Rezoning Transportation Analysis

Petition Number: 2021-160

Revision Log:

Date	Description
08-20-2021	First Review (WB)
09-17-2021	Second Review (WB)

Sheet No:
RZ-1

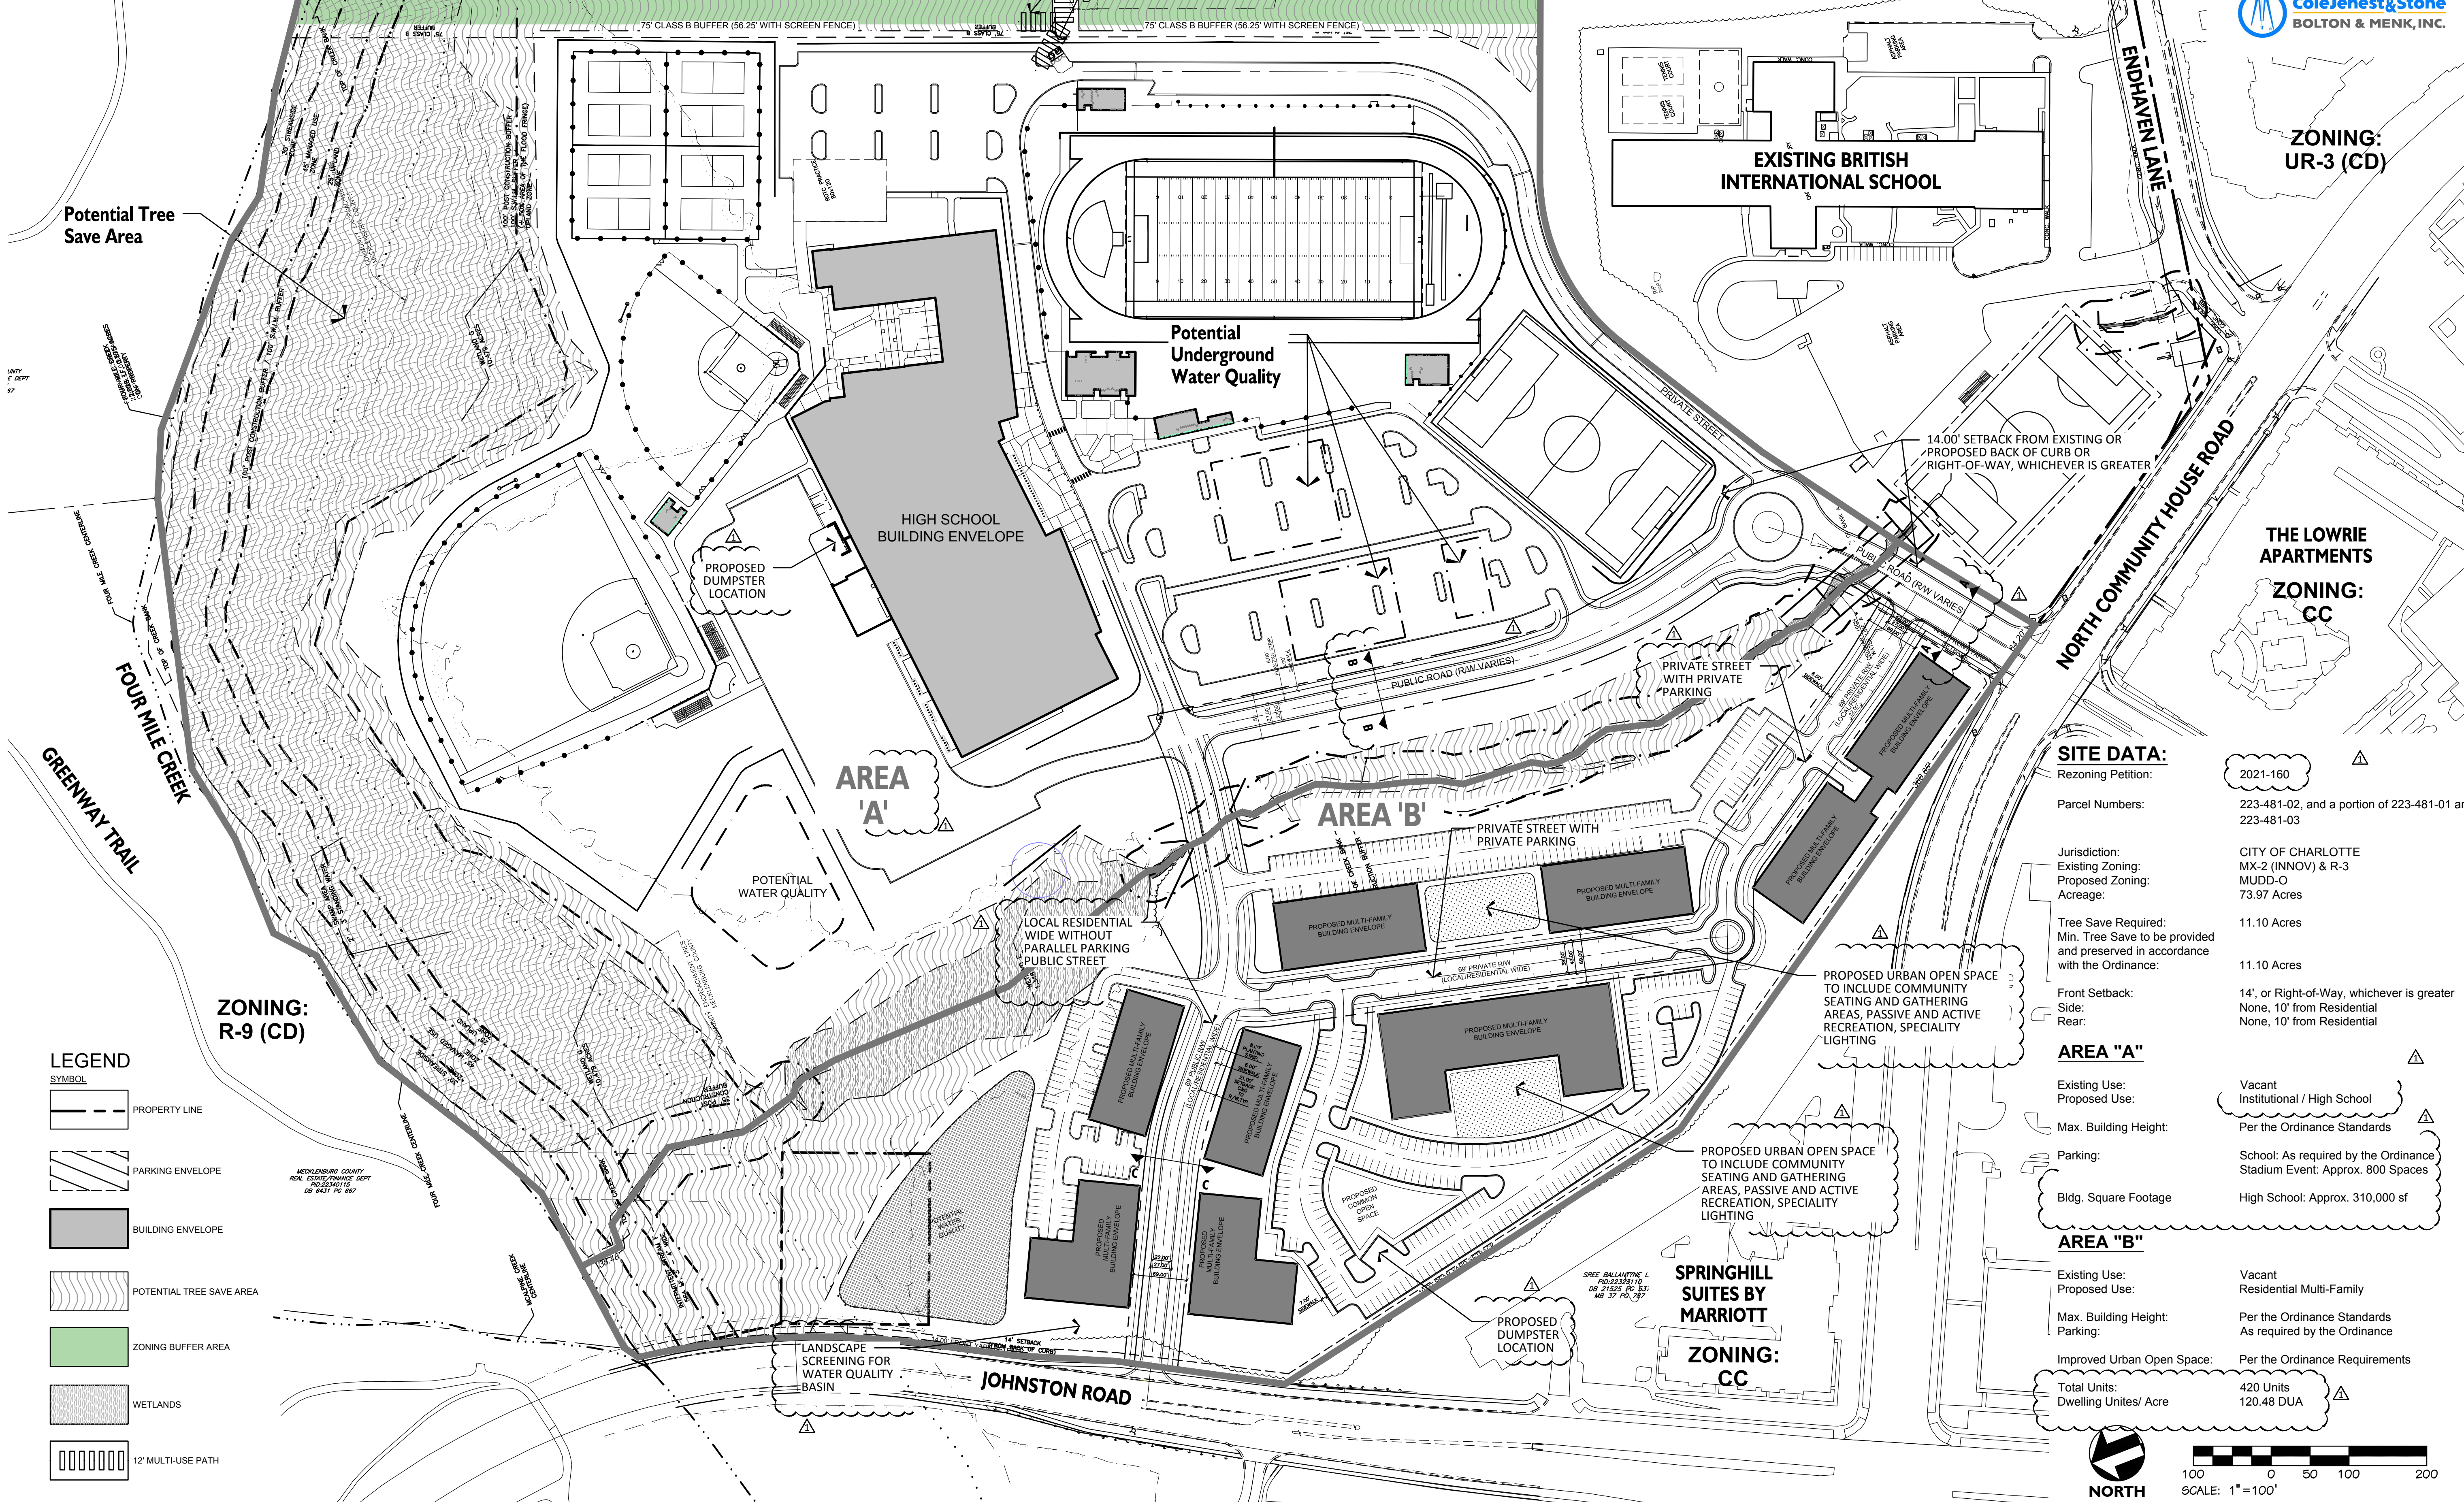
~~Label and dimension the curb and gutter from the centerline for each road on the site plan.~~

- 3. ~~Site plan and conditional note(s) revisions are needed to commit to construct a 12' multi-use path from the Barrette Place Stub into the site and northward, toward the greenway, in accordance with the Charlotte BIKES and Charlotte WALKS Plans.~~
- 4. ~~Revise site plan and conditional note(s) to identify, depict, label, dimension, and itemize all proposed transportation-related infrastructure improvements. The conditional notes should include commitments to fully construct and fund all TIS-recommended and ordinance-required transportation improvements with applicable phasing and funding sources identified.~~
- 5. ~~Add conditional note that all public transportation improvements will be constructed and funded by the residential development before the residential site's first building certificate of occupancy is issued.~~
